**From:** Cameron Sargent  
**To:** Michael Buckley  
**Date:** 21/09/2010 9:26 am  
**Subject:** Fwd: MP09\_0200 vehicle & pedestrian safety project Sydney Opera house  
**Attachments:** planning submission170910.pdf

Submission for Job: #3623 MP 09\_0200 - Vehicle & Pedestrian Safety Project  
[https://majorprojects.onhiive.com/index.pl?action=view\\_job&id=3623](https://majorprojects.onhiive.com/index.pl?action=view_job&id=3623)

*Vehicle and Pedestrian Safety Project at Sydney Opera House*

**SYDNEY OPERA HOUSE - VAPS PROJECT  
ENVIRONMENTAL ASSESSMENT  
VEHICLE RAMP SECTION E**

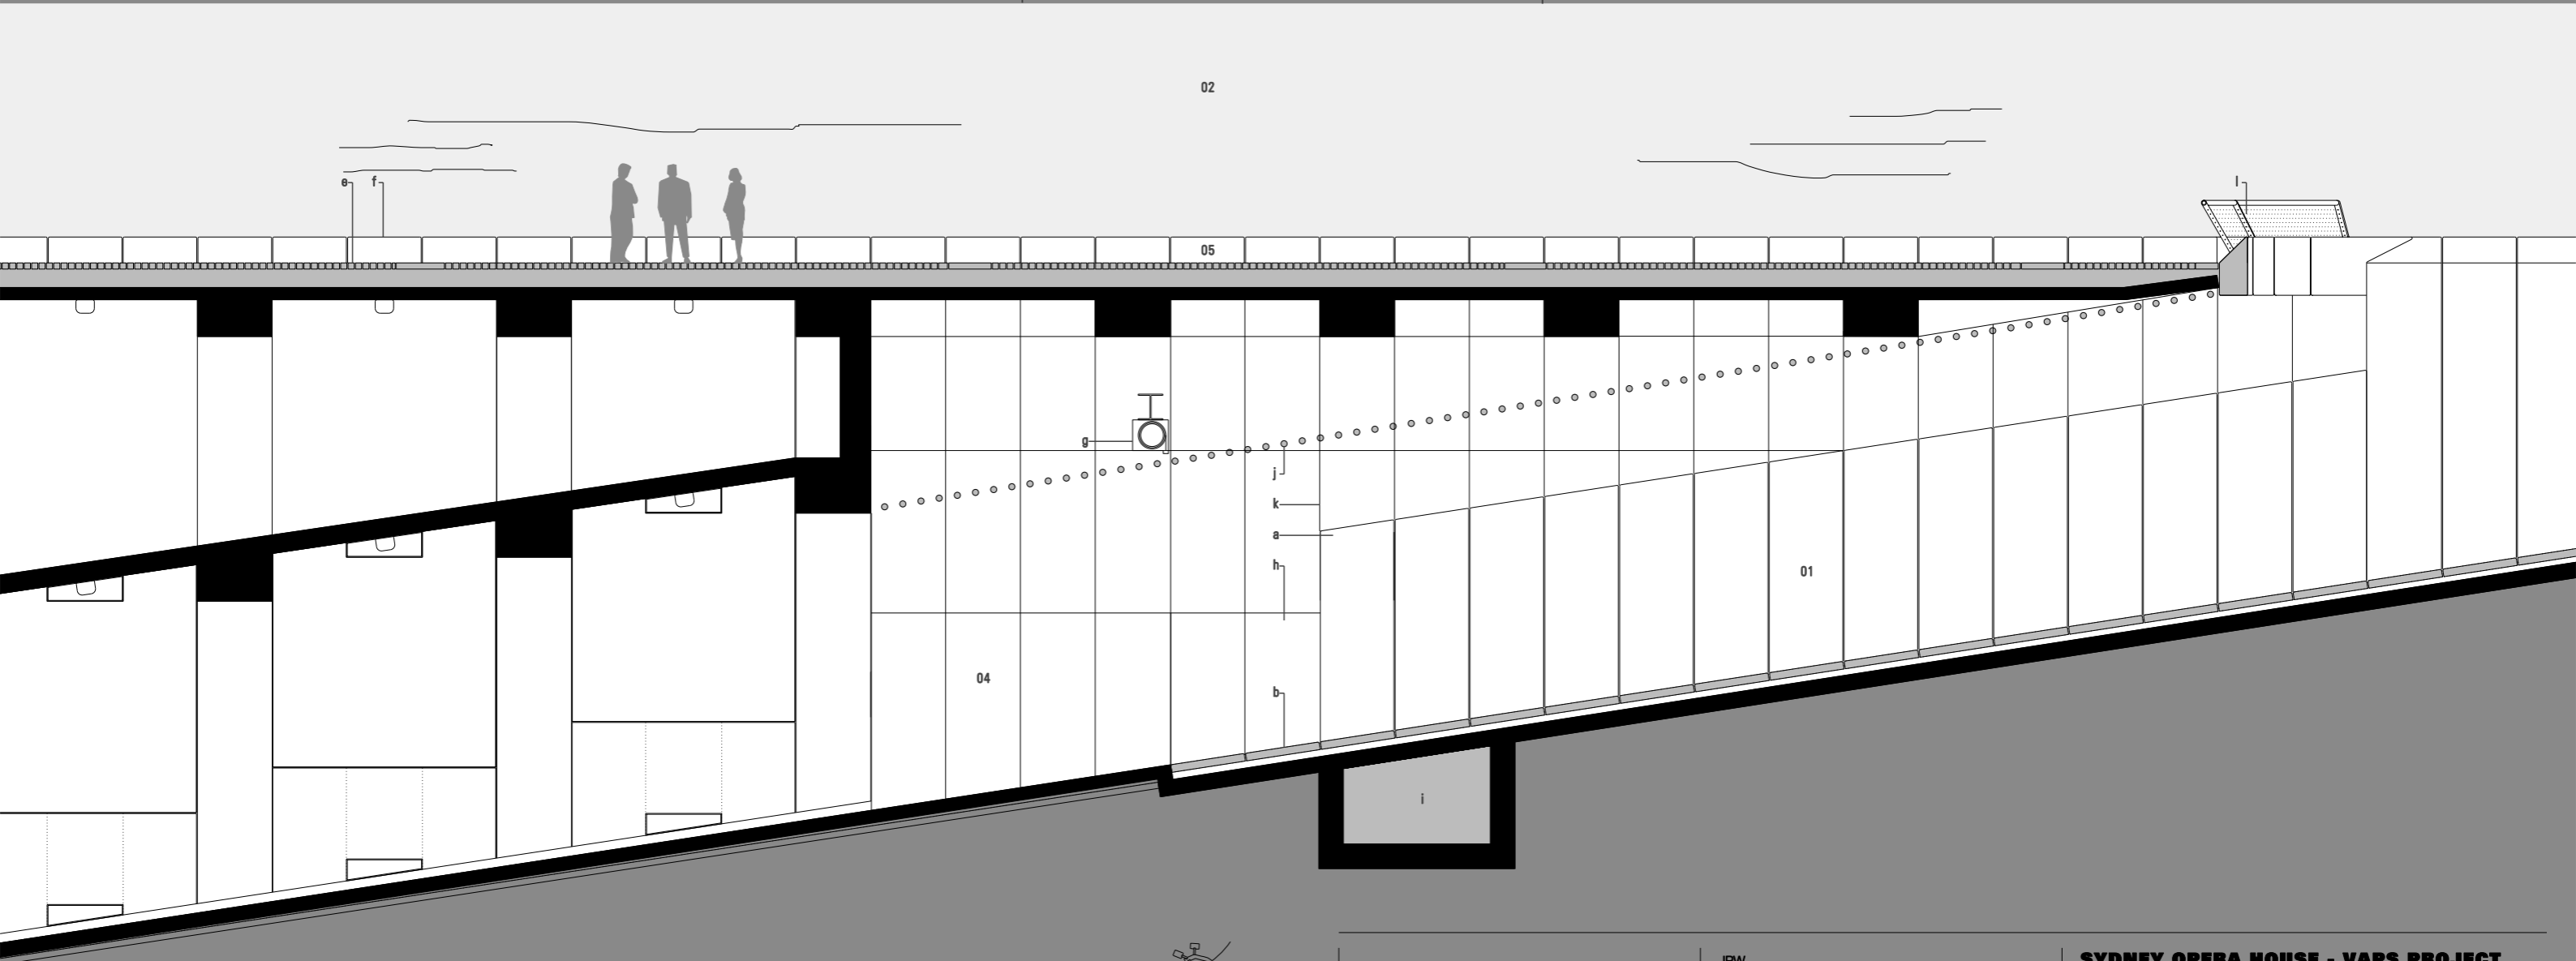
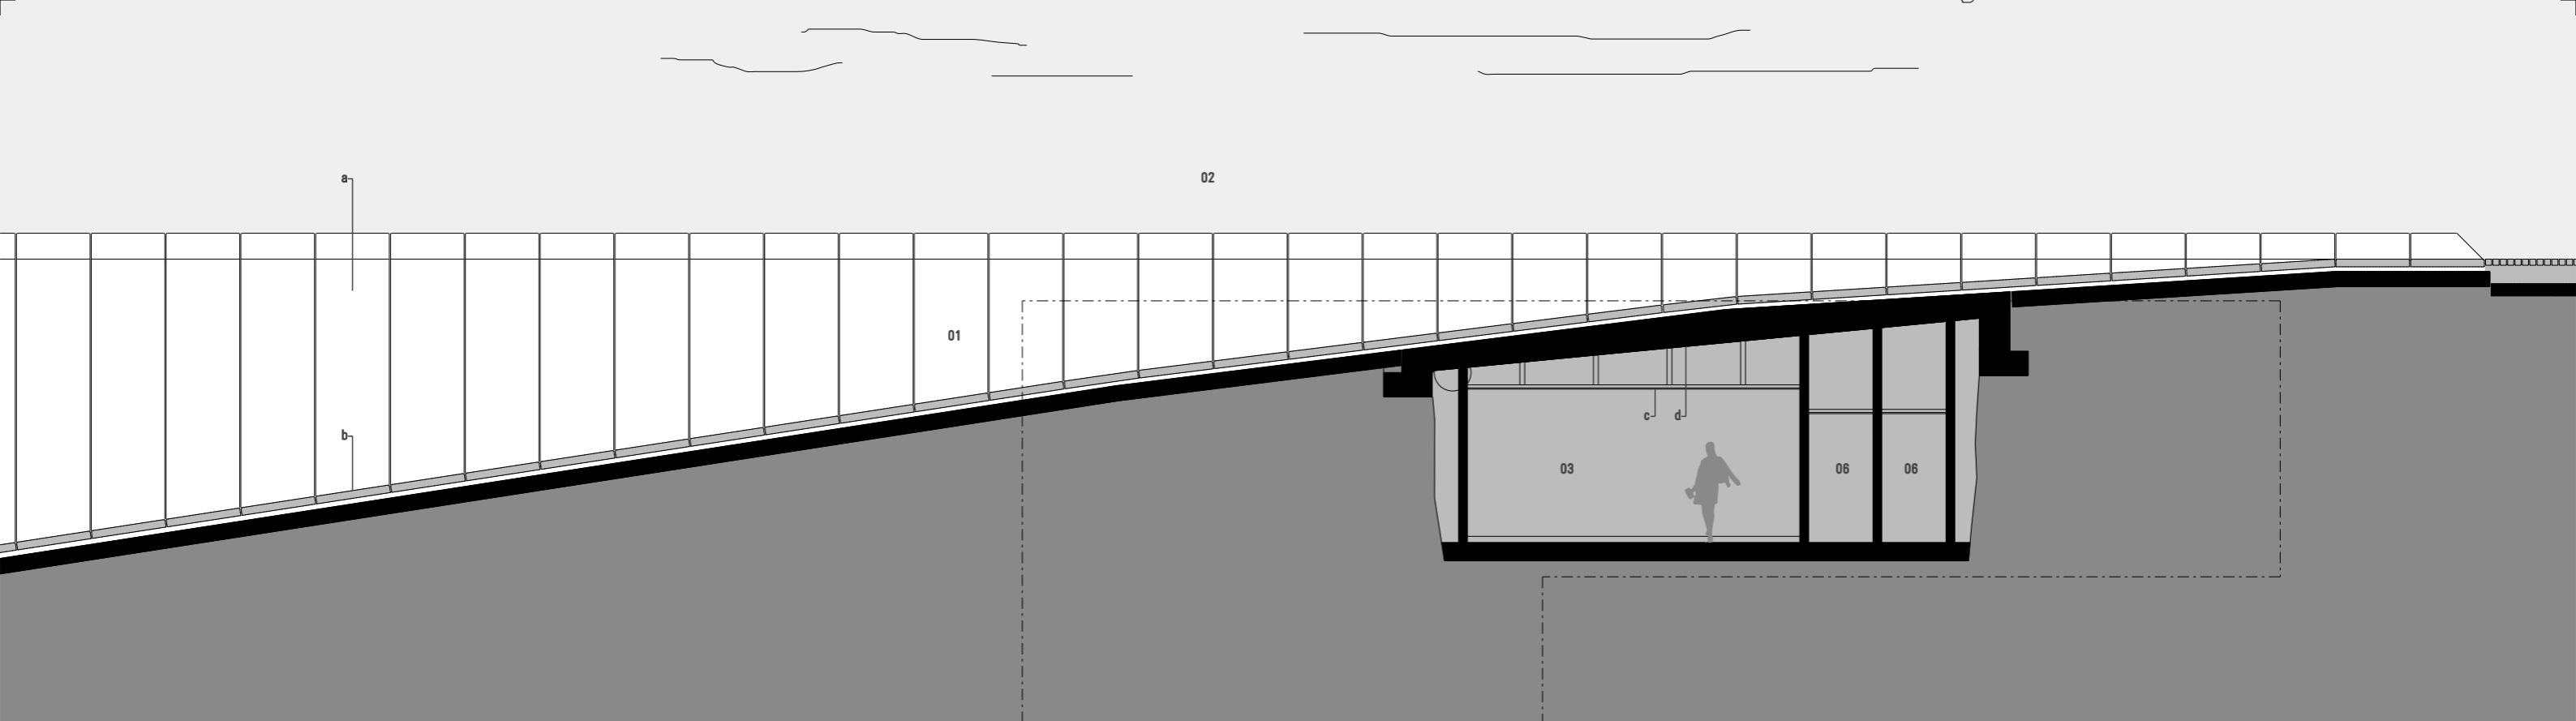
014	Mechanical Ventilation	Will the volume of air be reduced/restricted as it appears that the size of the air intake shaft & air grilles is being reduced?	Will this limit any future potential to increase air volumes into the car park?
015	Noise	Noise impact during construction and post construction on the car park operations?	Pedestrian tunnel particularly.
016	Odour	How will odour/smells that may be present during the works be addressed?

**SYDNEY OPERA HOUSE - VAPS PROJECT  
ENVIRONMENTAL ASSESSMENT  
SECTION JJ VEHICLE RAMP AND  
PEDESTRIAN TUNNEL**

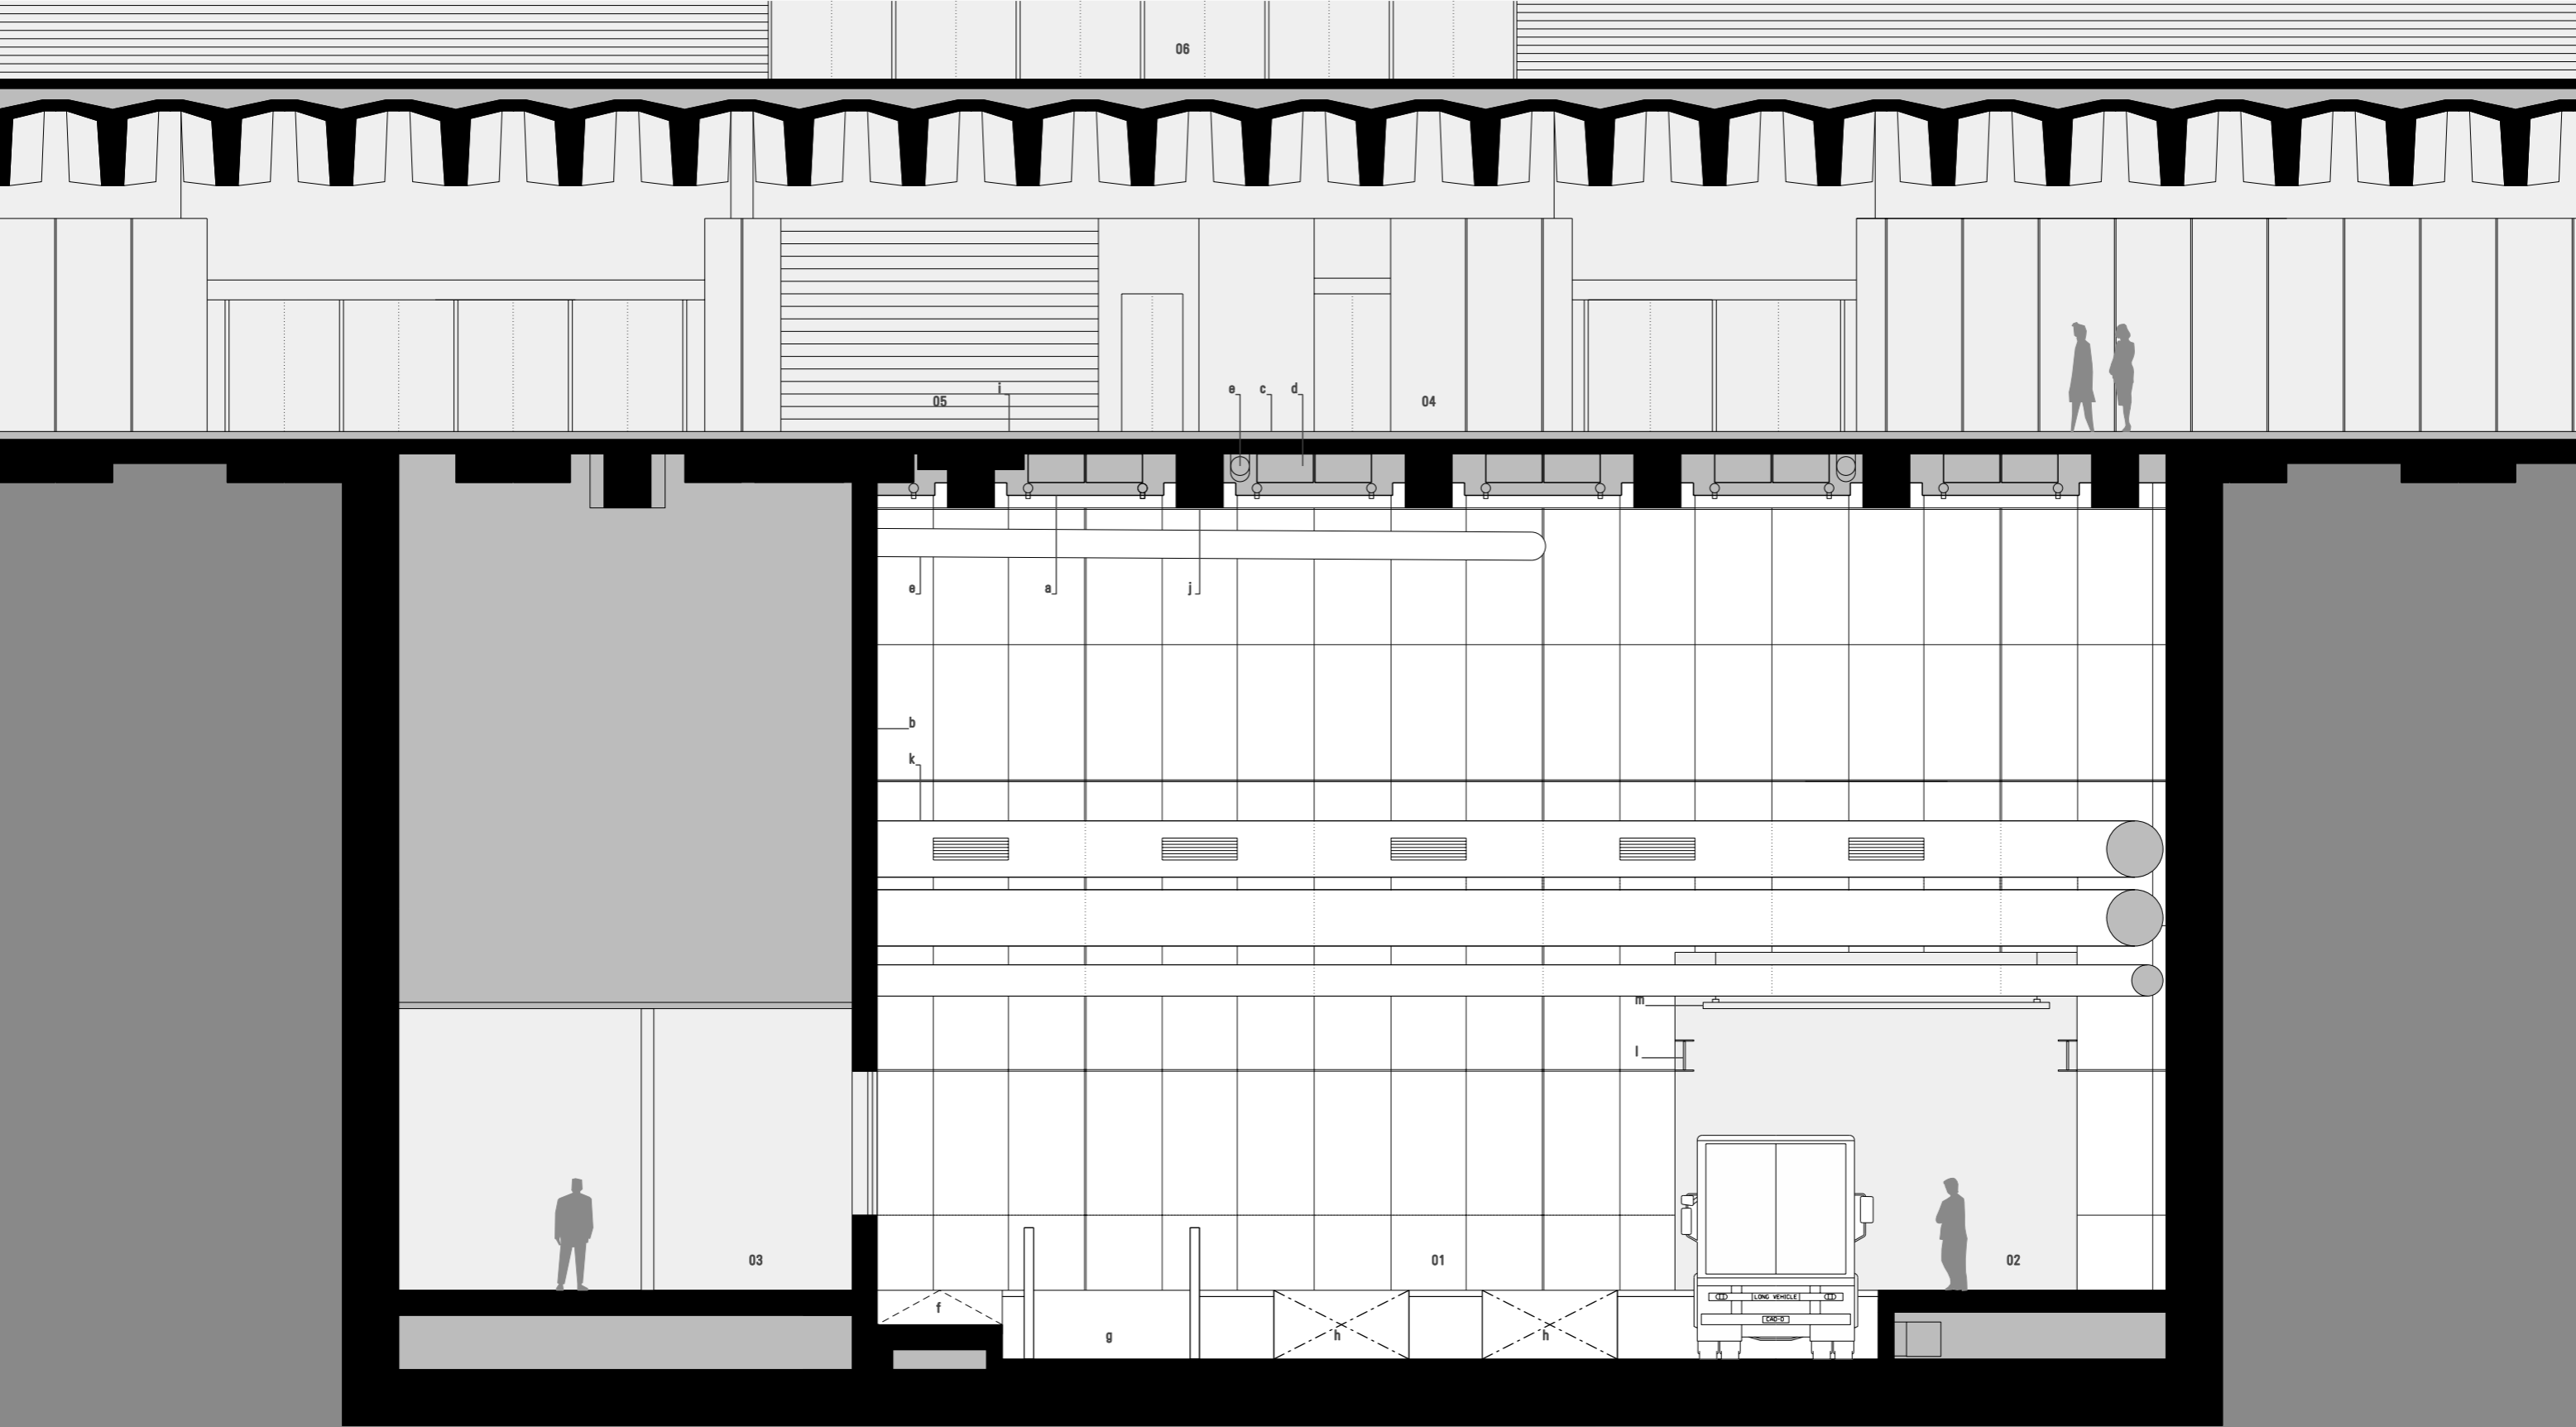
023	Structural stability	Structural stability of the pedestrian access tunnel prior to the works being undertaken?	Will construction vehicles cause an issue?
024	Structural stability	How will the work affect the shoring/anchoring of the car park structure?	
025	Timing	What is the anticipated timing & duration of the project?	Anticipated start early 2011 and the project is targeted for completion in mid 2013; Are these dates still accurate; Project programme required.
